## Application for a Non-Material Amendment Following a Grant of Planning Permission

Single storey kitchen pitched roof with exposed kitchen extract to be removed, and new brickwork wall with timber windows and parapet upstand to conceal flat roof over installed to match in with existing elevation

CURRENT APPROVED
PROPOSED FRONT ELEVATION
SCALE 1:100

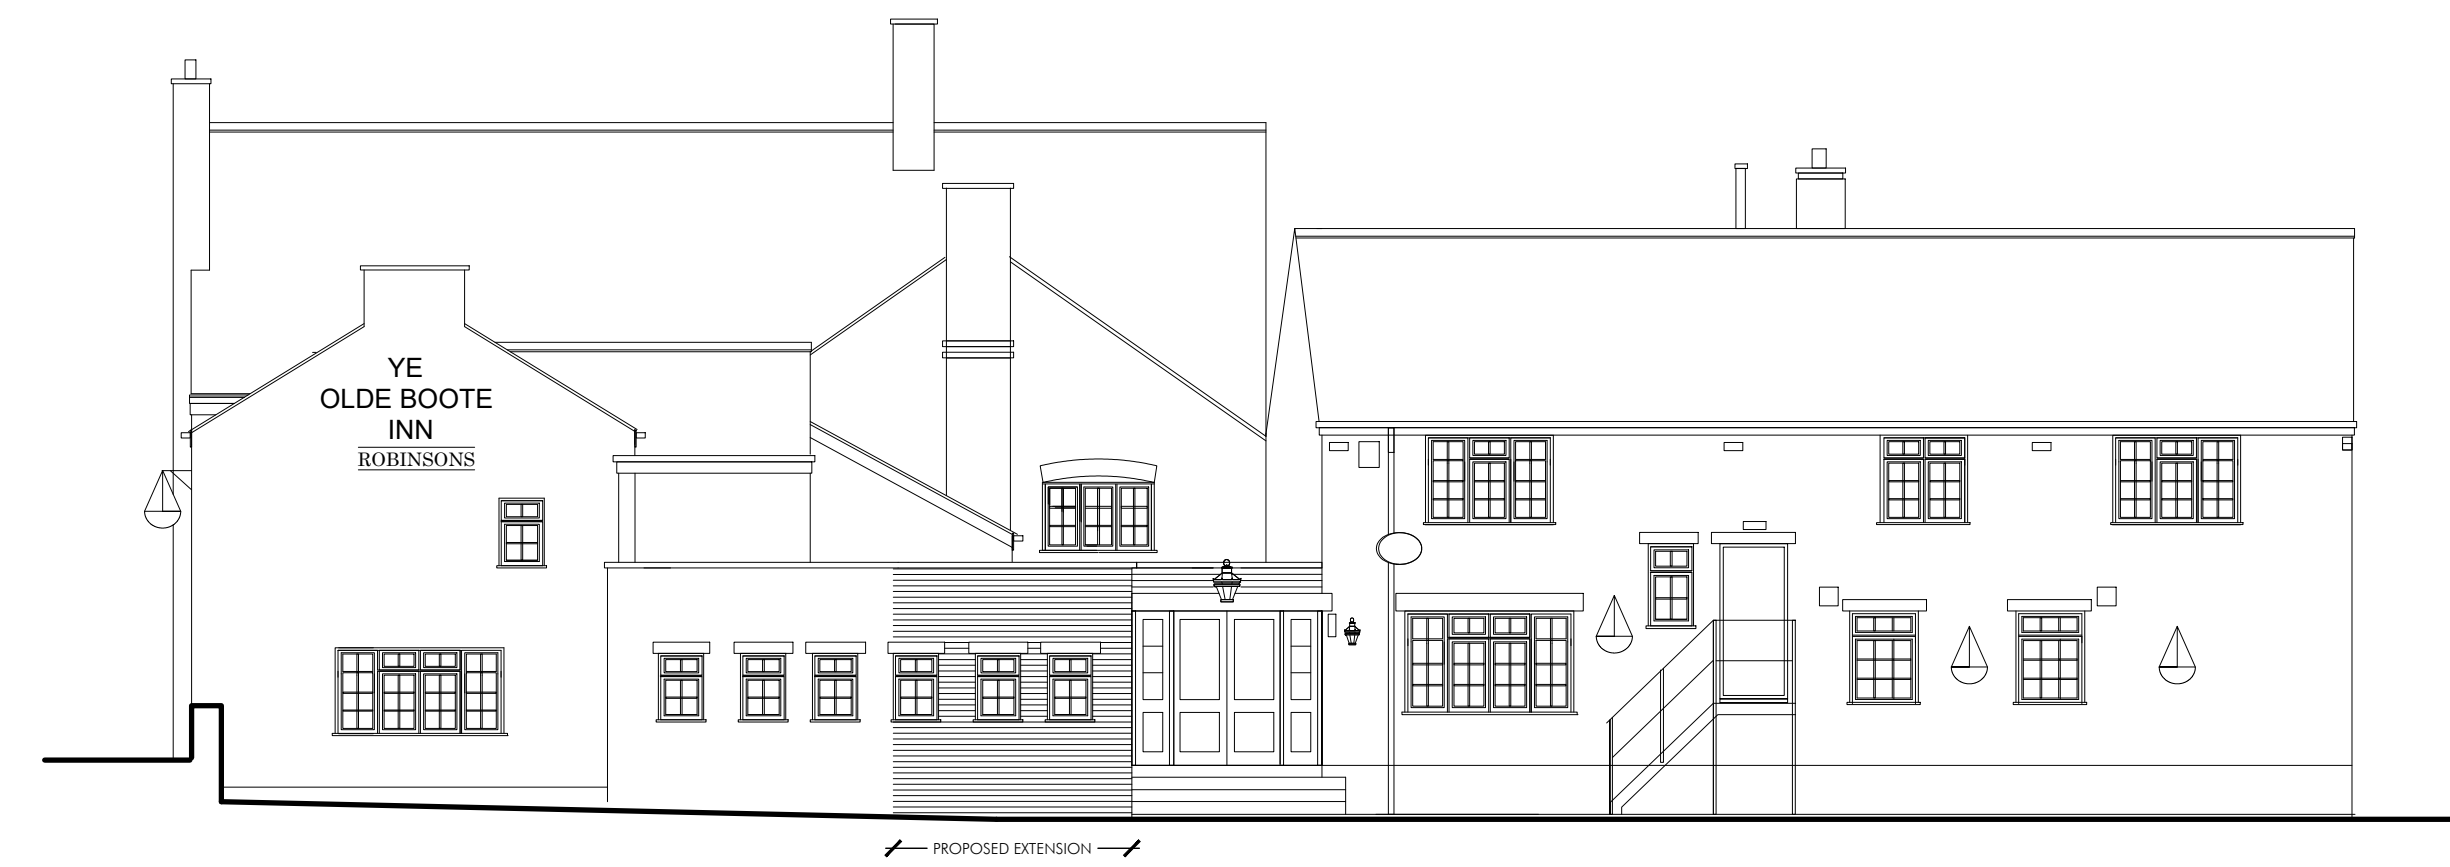
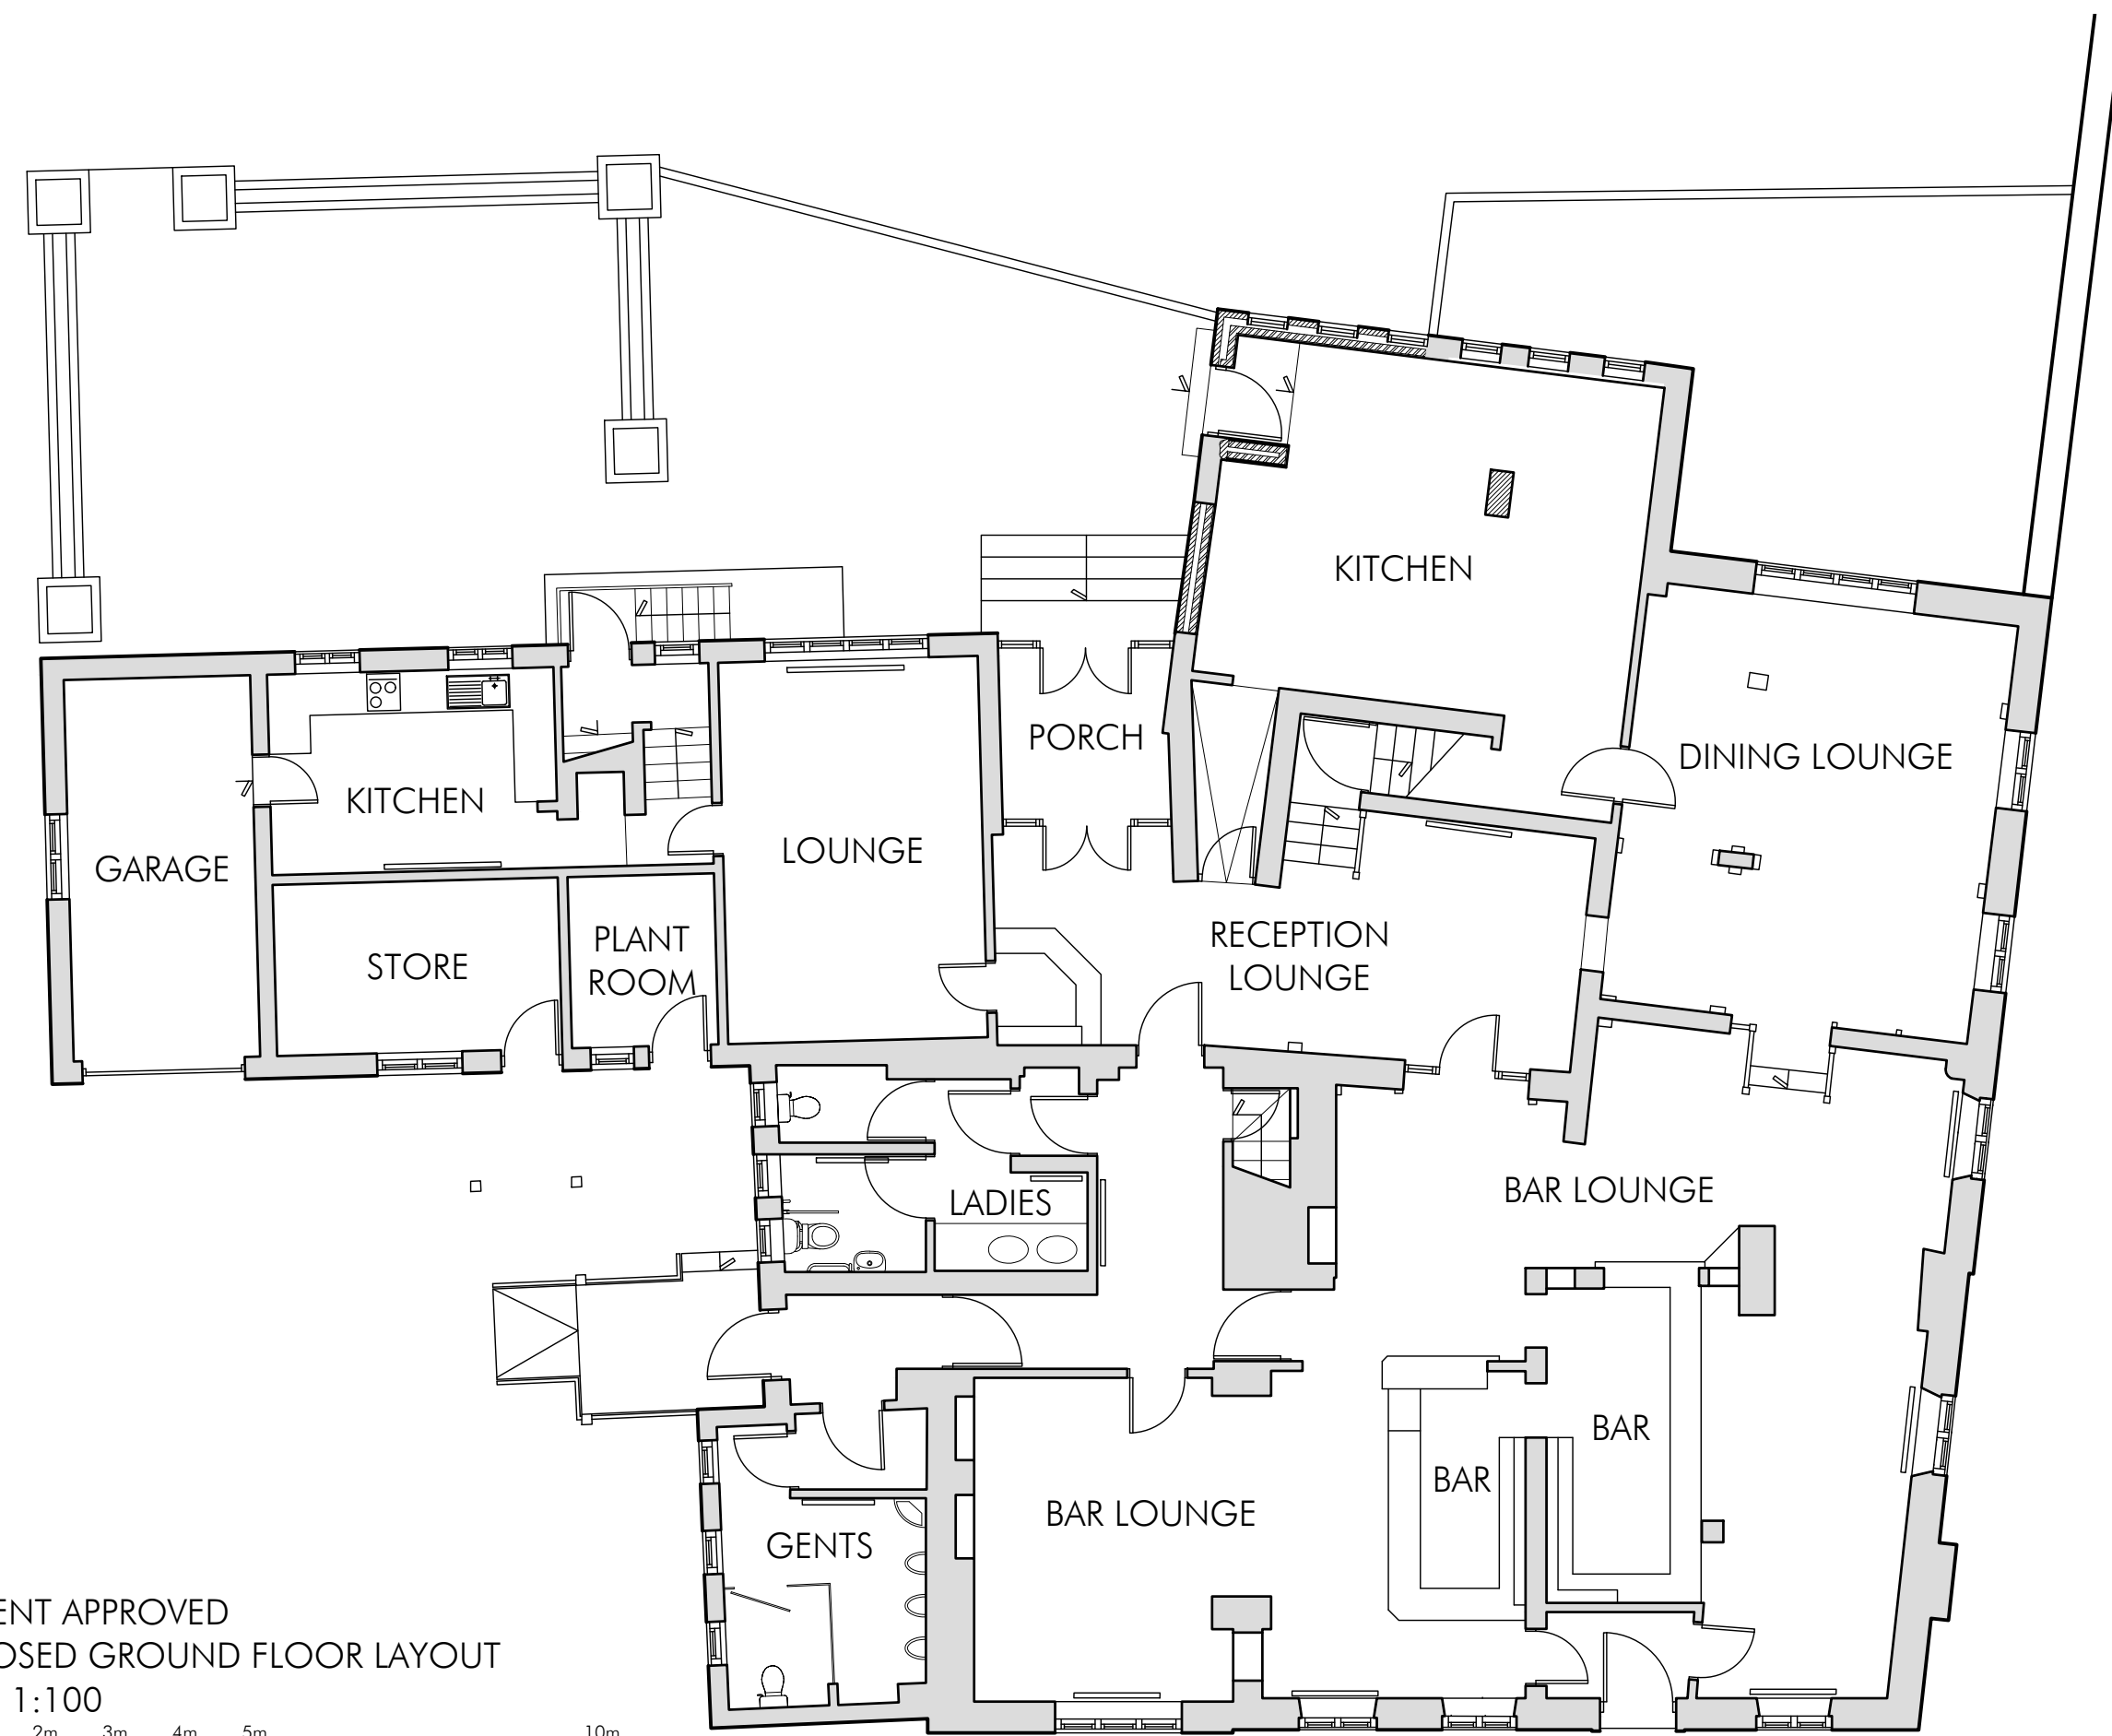
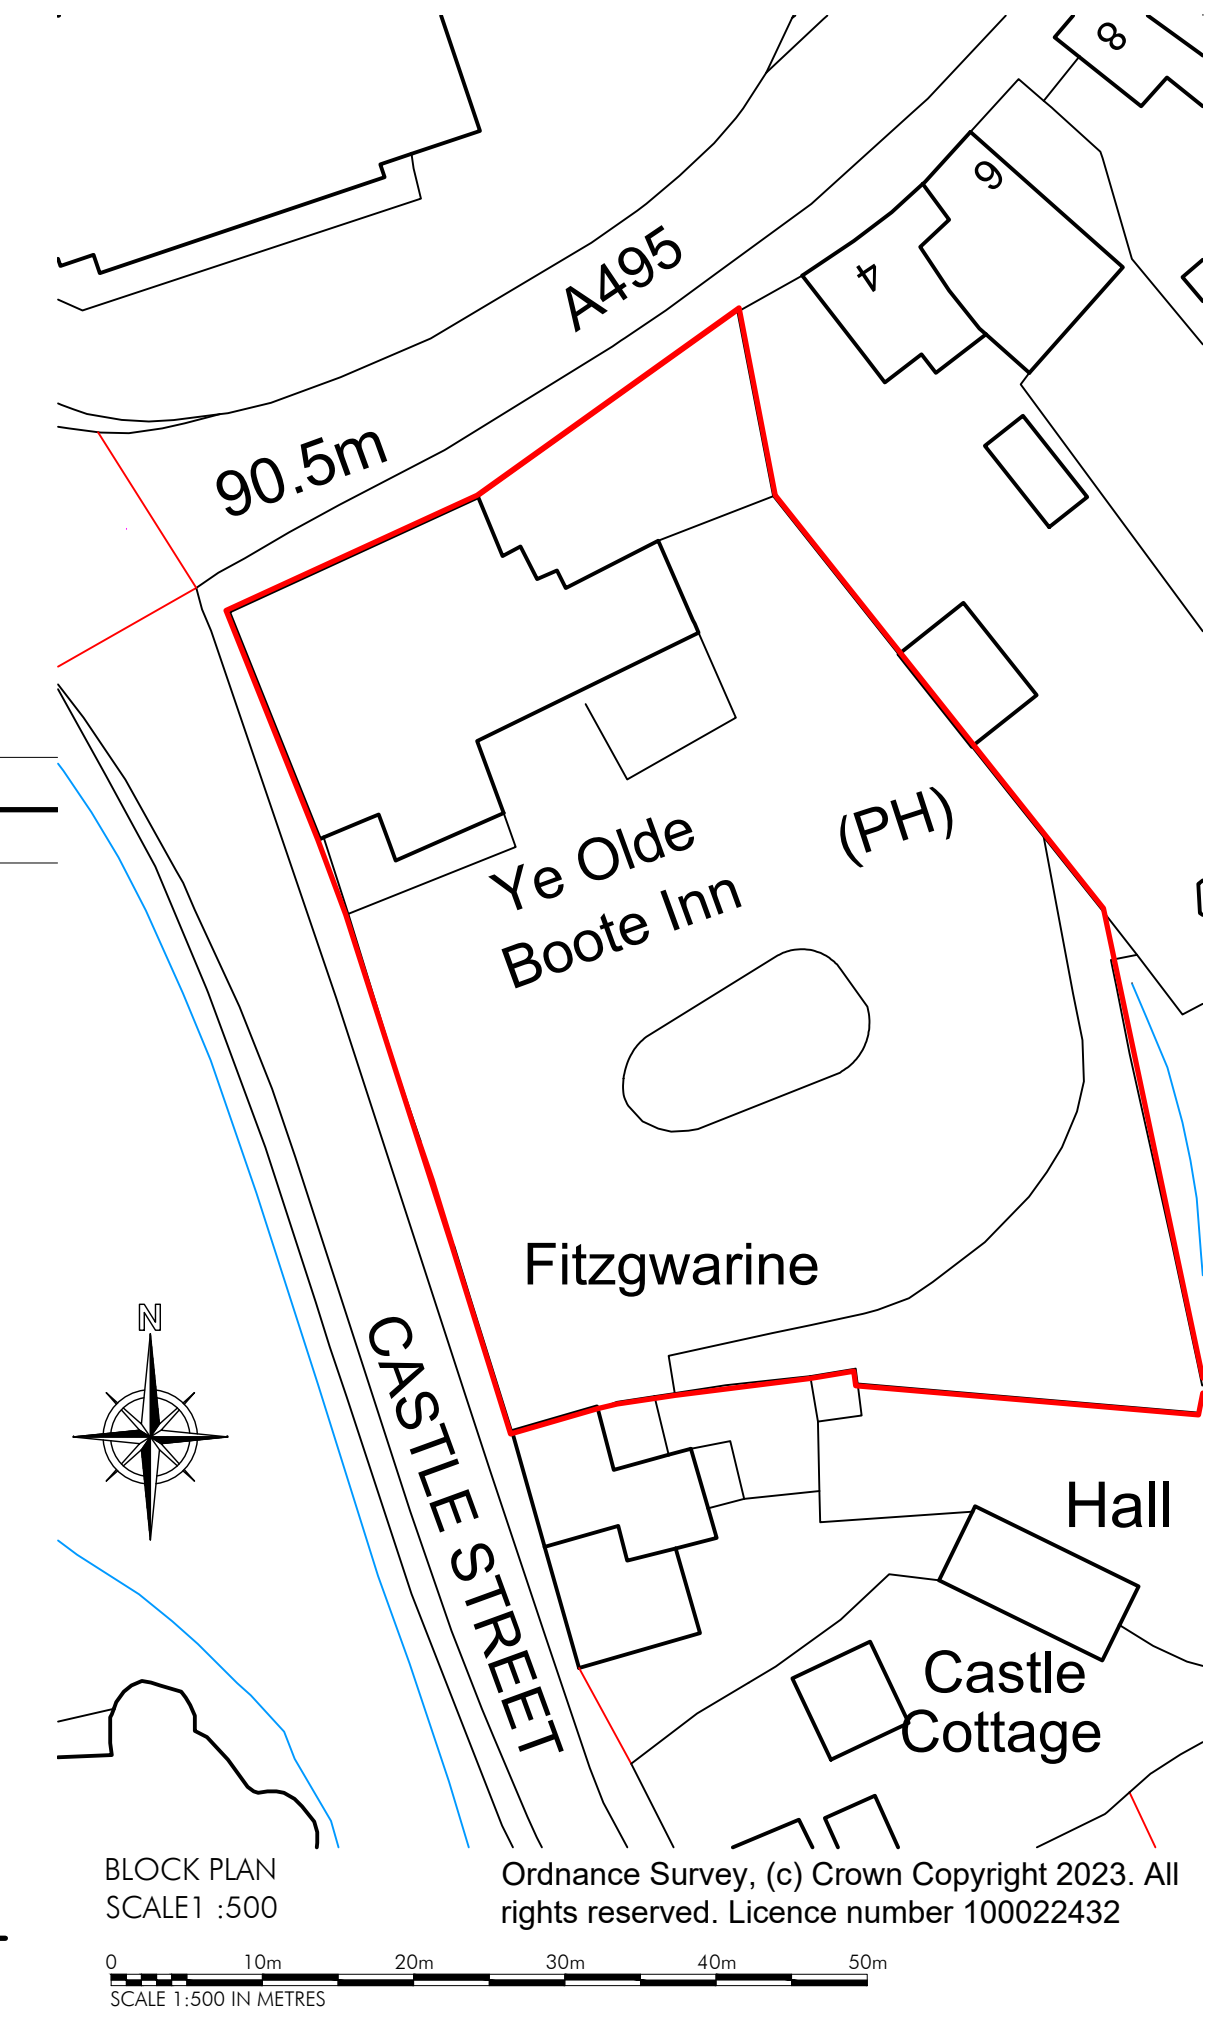
1no Door was removed from Side Elevation,  
2no windows removed from the Rear Elevation  
1no Door opening added to the Rear Elevation

To allow ramped access from the carpark into the public house
